Application by Highways England for a Development Consent Order in relation to the A585 Windy Harbour to Skippool Improvement Scheme

The Examining Authority's further written questions and requests for information (ExQ2)

Issued on 23 July 2019

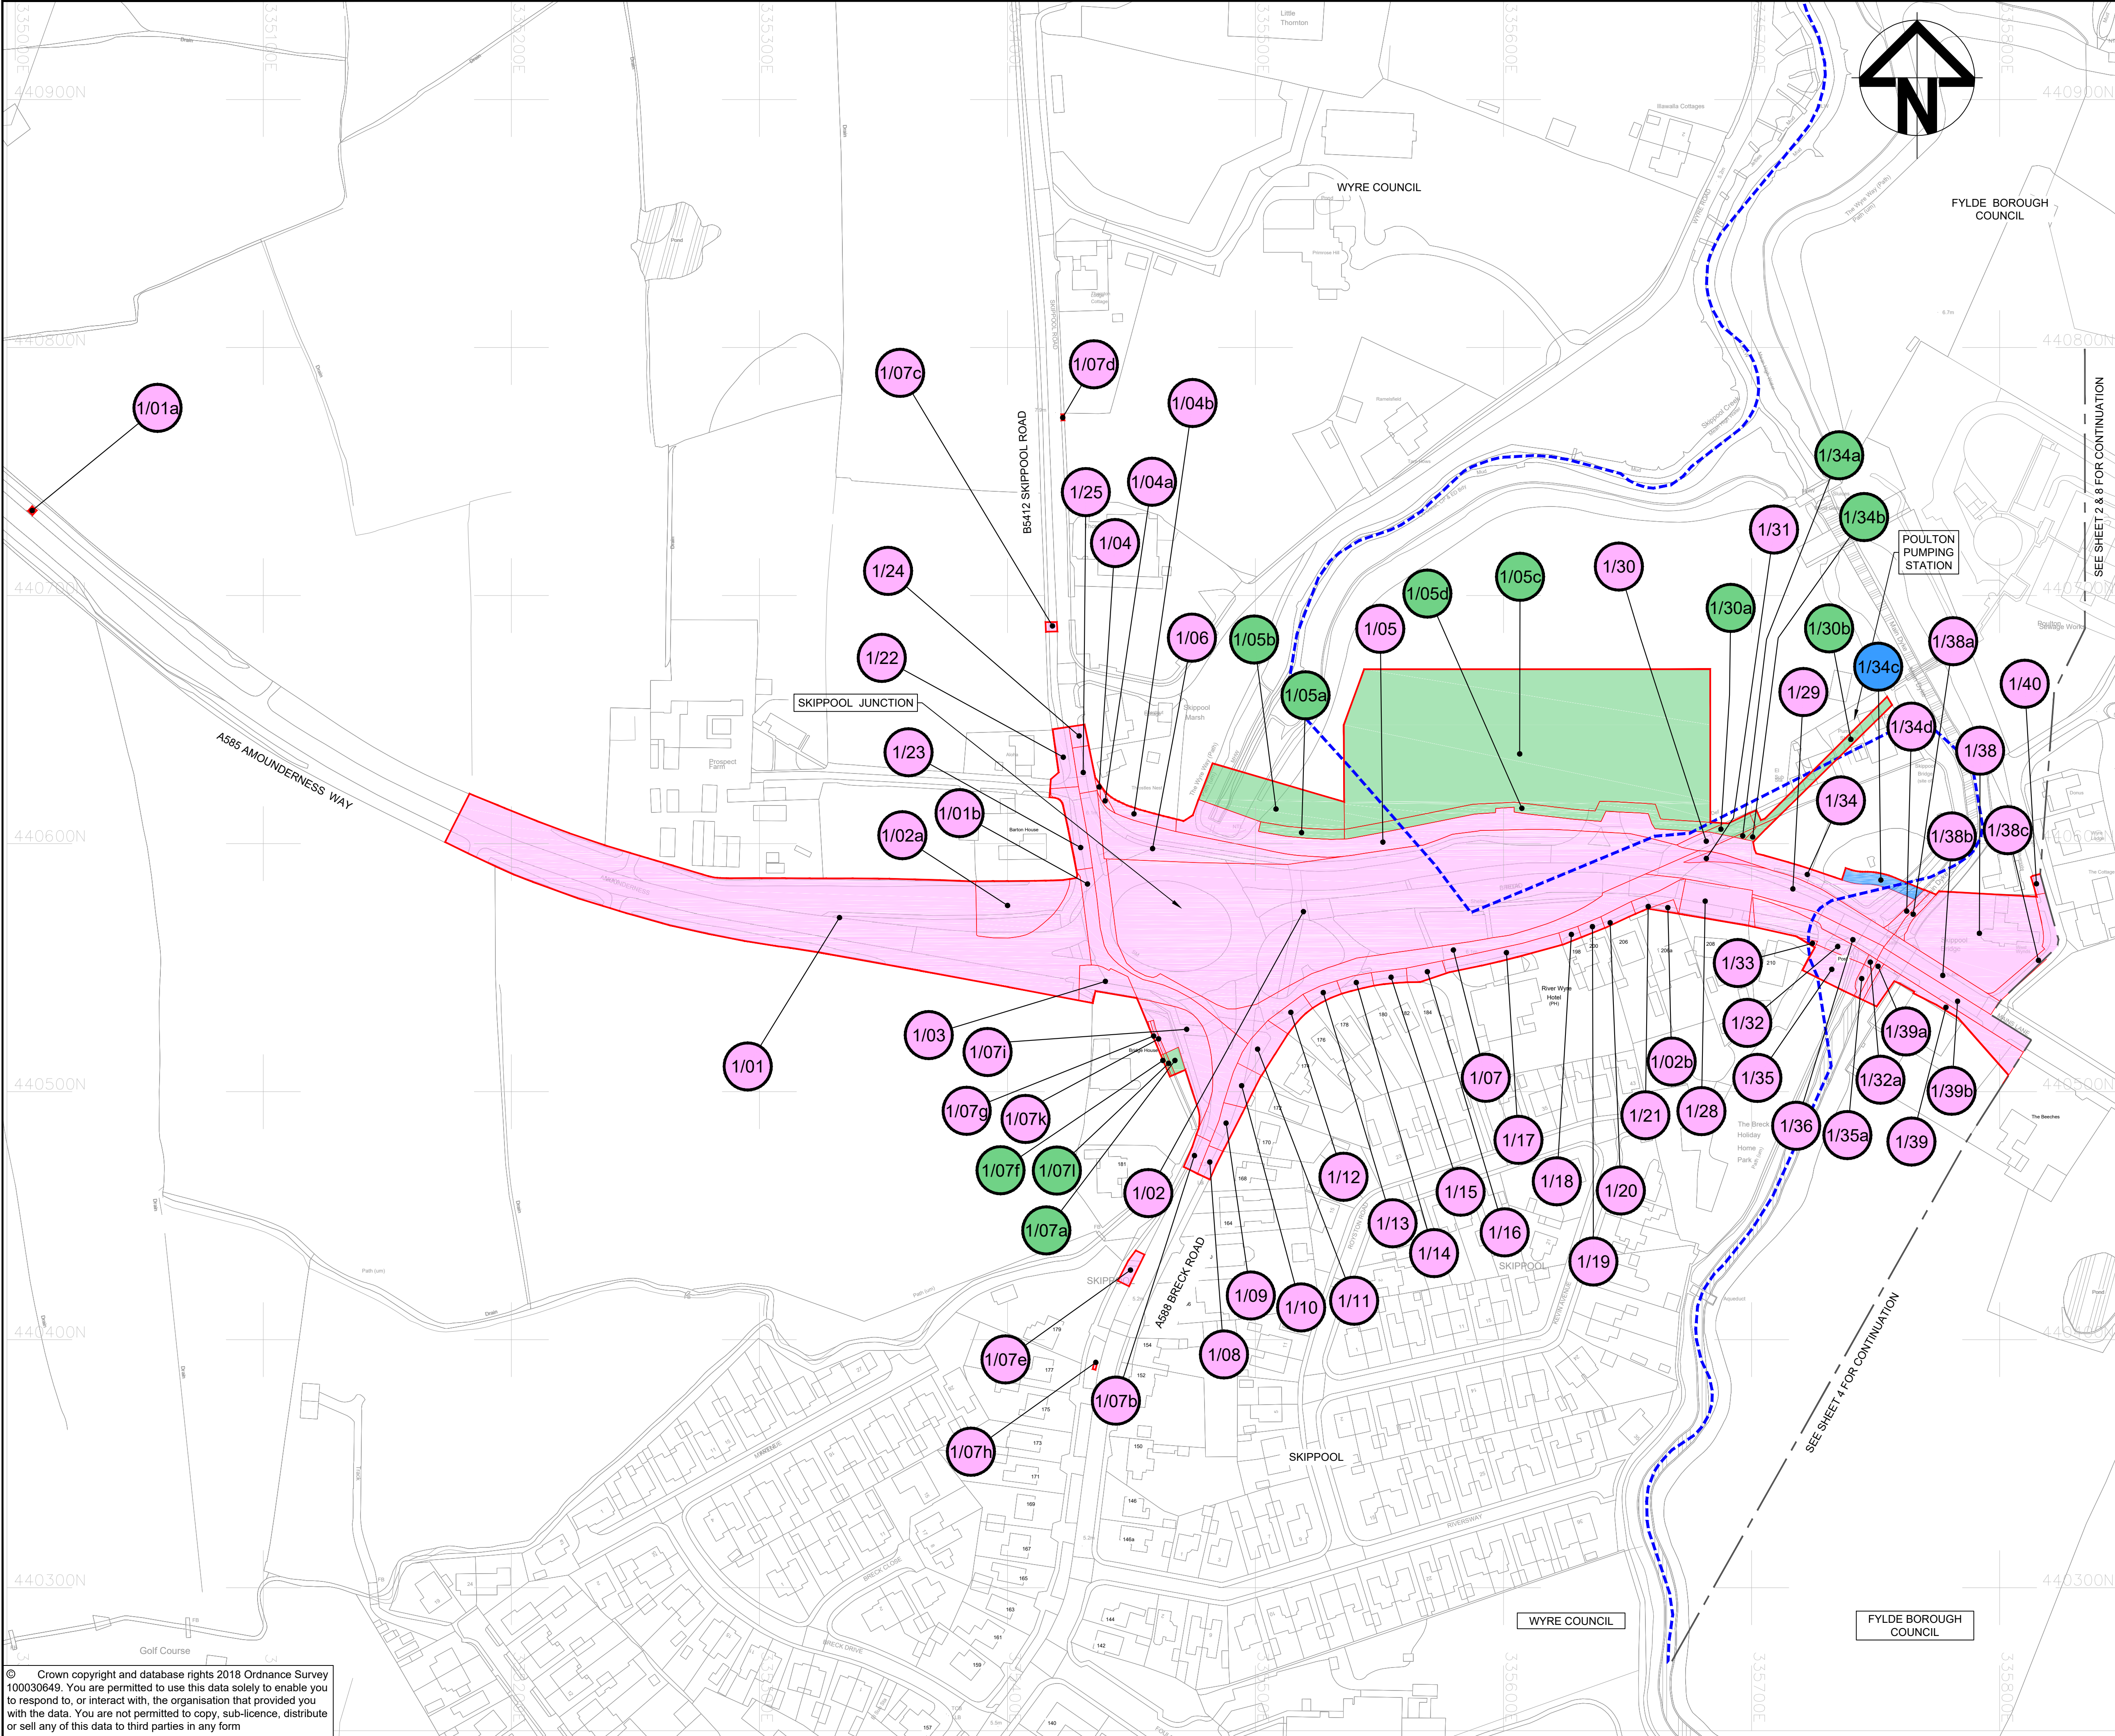
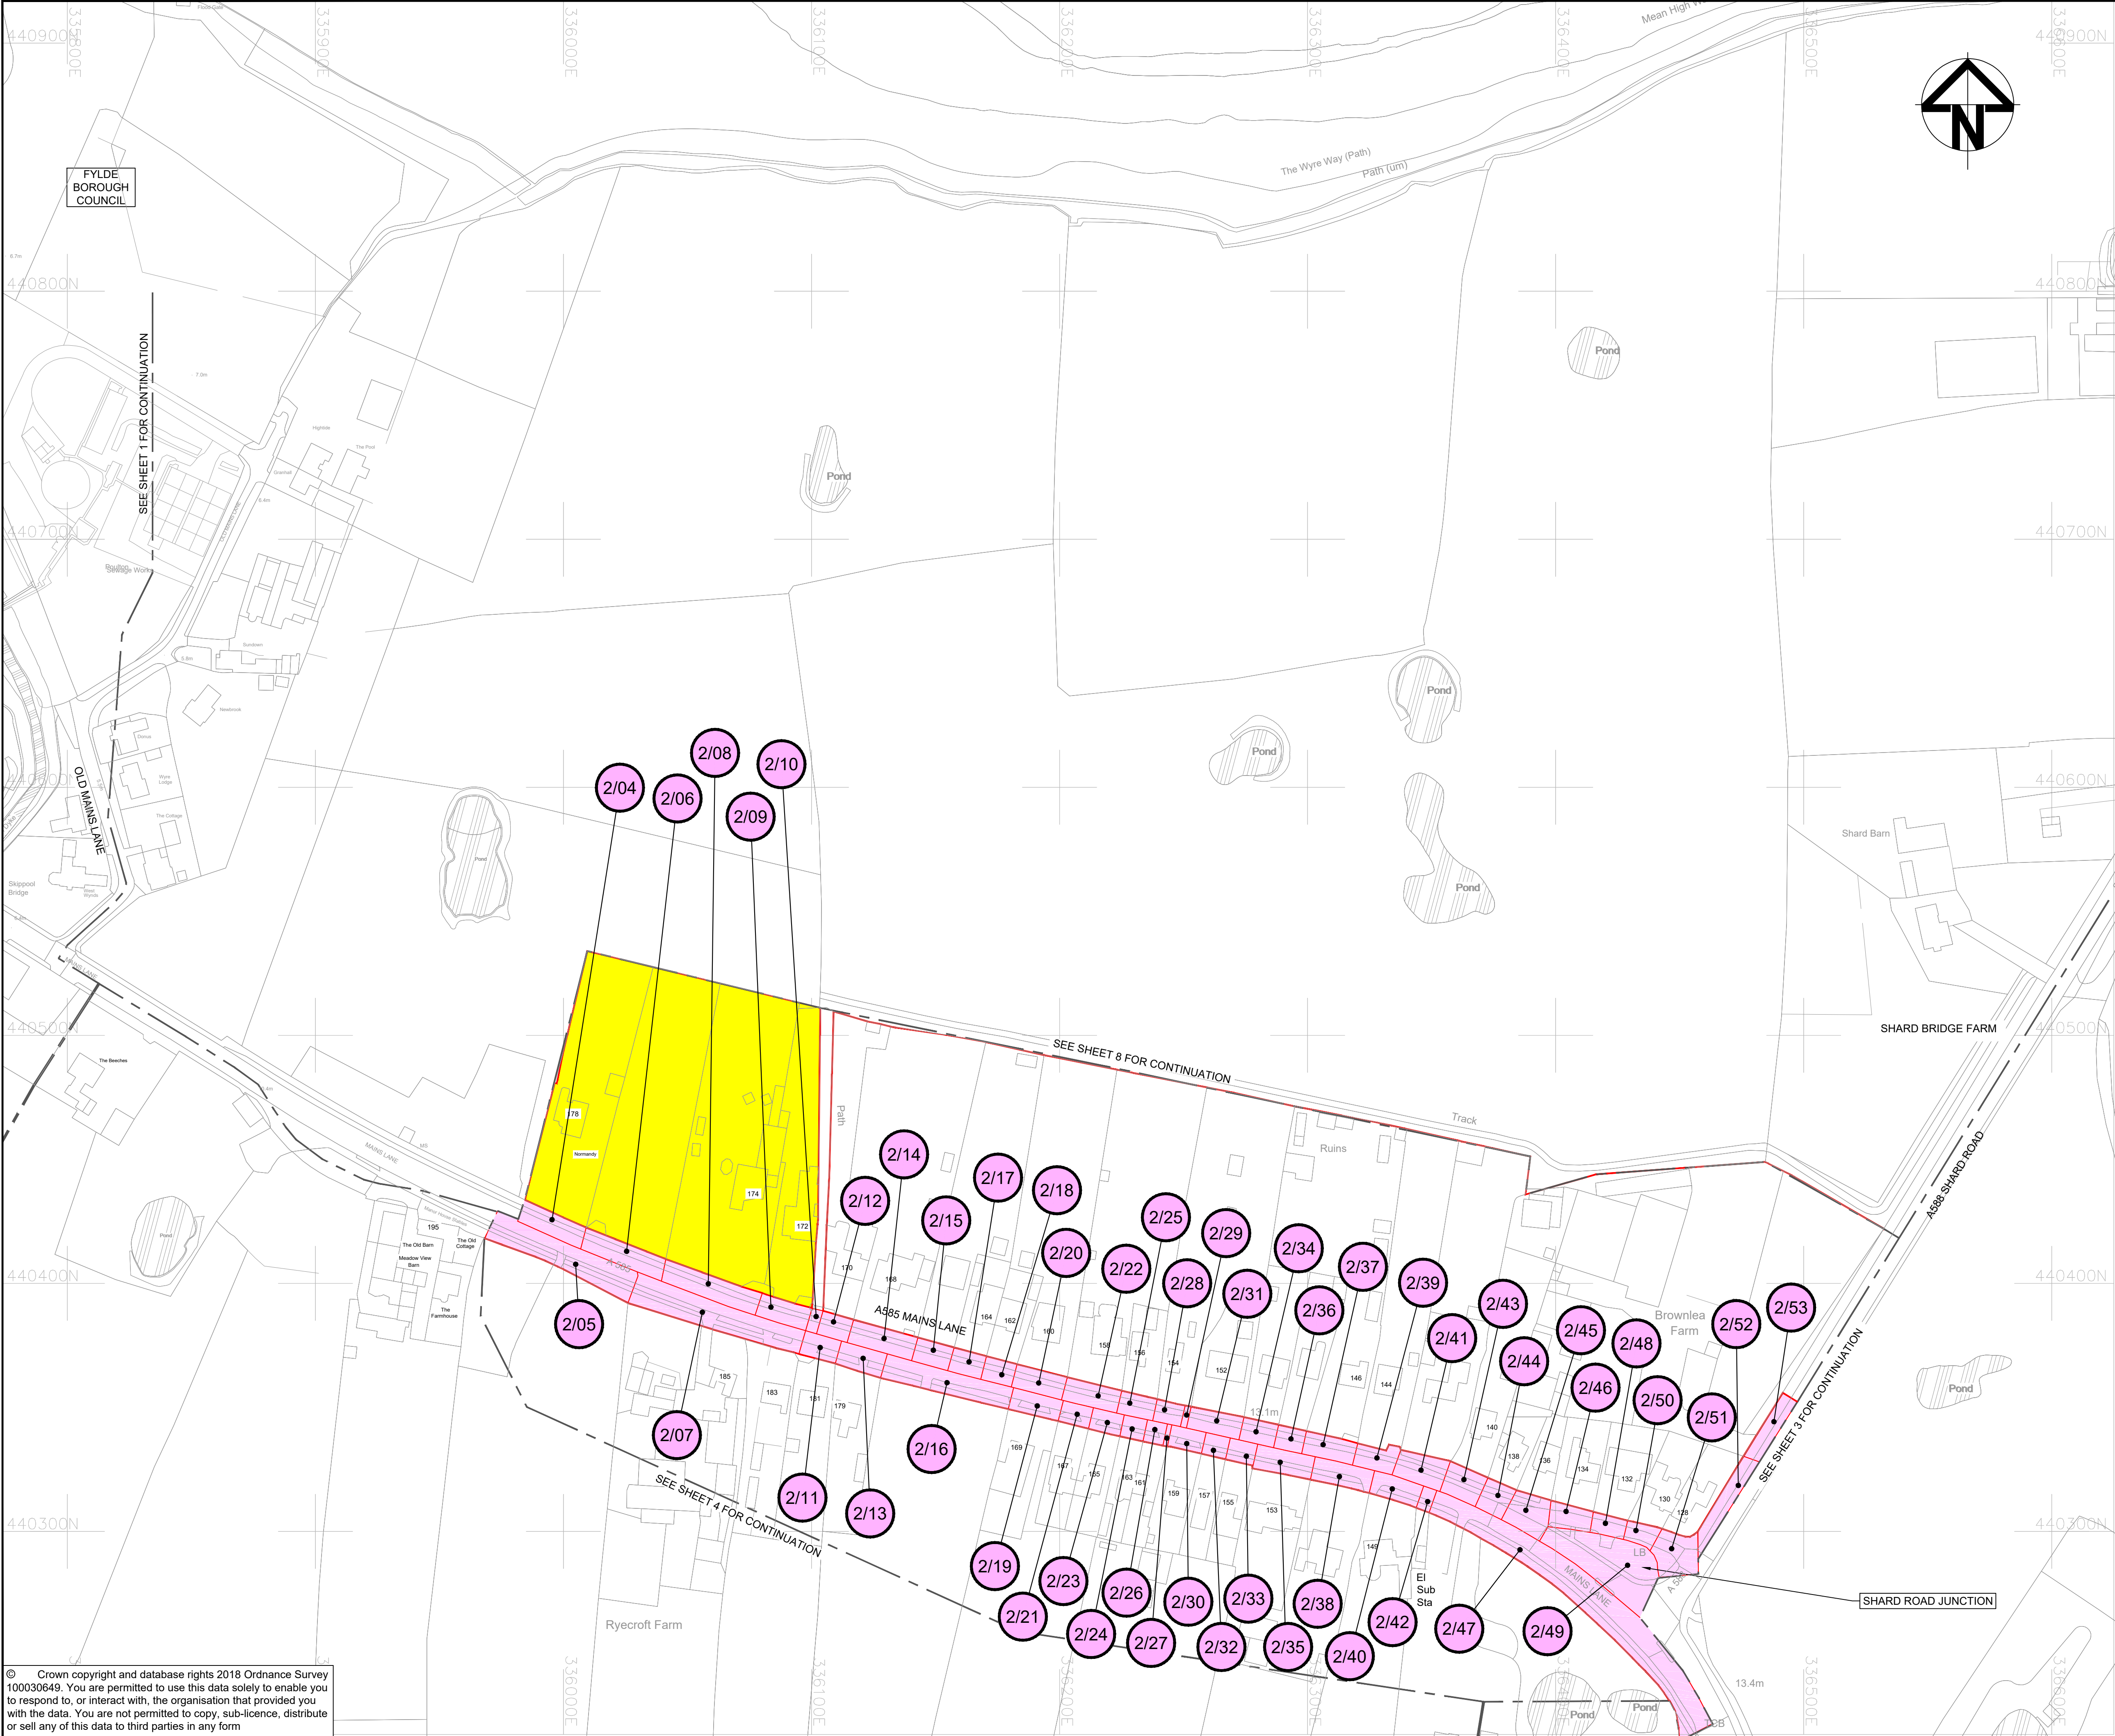
2.2.27.	The Applicant	<p>Area not included in the DCO boundary What is the area identified on the Land and Work Plans in yellow as “area not included in the DCO boundary”?</p> <p>It appears from the plans that this area is within the “order limits” i.e. within the red line boundary on the plan. The “order limits” are defined in the DCO as “the limits of land to be acquired or used permanently or temporarily shown on the Land Plans and Work Plans within which the authorised development may be carried out”. There is no definition of “DCO boundary”. Please explain what the “DCO boundary” is and how this interacts with the “order limits”.</p> <p>Please explain how the area identified as “area not included in the DCO boundary” relates to the dDCO, in particular to the works and CA for which authorisation is sought.</p>
